# Permit Inspections

**Permit Number: BRES2309-0011**

Description: **16x23 Sunroom**

Site Address: **485 TYLERSTONE DR**

**WALL FRAMING PLAN**  
1/8" = 1'

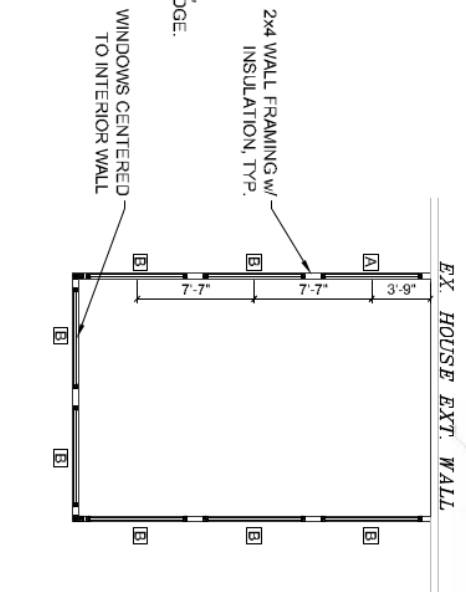
SEQ ID	SCHEDULED DATE	COMPLETED DATE	TYPE	INSPECTOR	RESULT	REMARKS
			FOUNDATION	Justin Ryan McLeod		
Notes:						
			MONO SLAB	Justin Ryan McLeod		
Notes:						
			OPEN FLOOR	Justin Ryan McLeod		
Notes:						
			SLAB	Justin Ryan McLeod		
Notes:						
			FOOTING	Justin Ryan McLeod		
Notes:						
	1/30/2024	1/30/2024	FOOTING	Justin Ryan McLeod	DISAPPROVED	
Notes: Missing footings where old deck band was . not per engineers stamped plan						
	1/31/2024	1/31/2024	FOOTING	Daniel L Floyd	APPROVED	
Notes:						
	2/12/2024	2/12/2024	ROUGH IN	Daniel L Floyd	DISAPPROVED	
Notes: Not ready, needs all exterior doors and windows installed, needs fire stop at all penetration through the top and bottom plate, need plans onsite, will need more king studs on openings according to the 2018 NCRBC R602.7.5

3/14/2024	3/14/2024	ROUGH IN REINSPECT	Justin Ryan McLeod	DISAPPROVED	
Notes: Add king stud beside door to make 2 kings, collar ties per plan installed per code ok to insulate						
	3/19/2024	3/19/2024	ROUGH IN REINSPECT	Brad Sutton	APPROVED	
Notes:						
	3/19/2024	3/19/2024	INSULATION	Brad Sutton	APPROVED	
Notes:						
	4/8/2024	4/8/2024	FINAL**	Justin Ryan McLeod	APPROVED	
Notes:
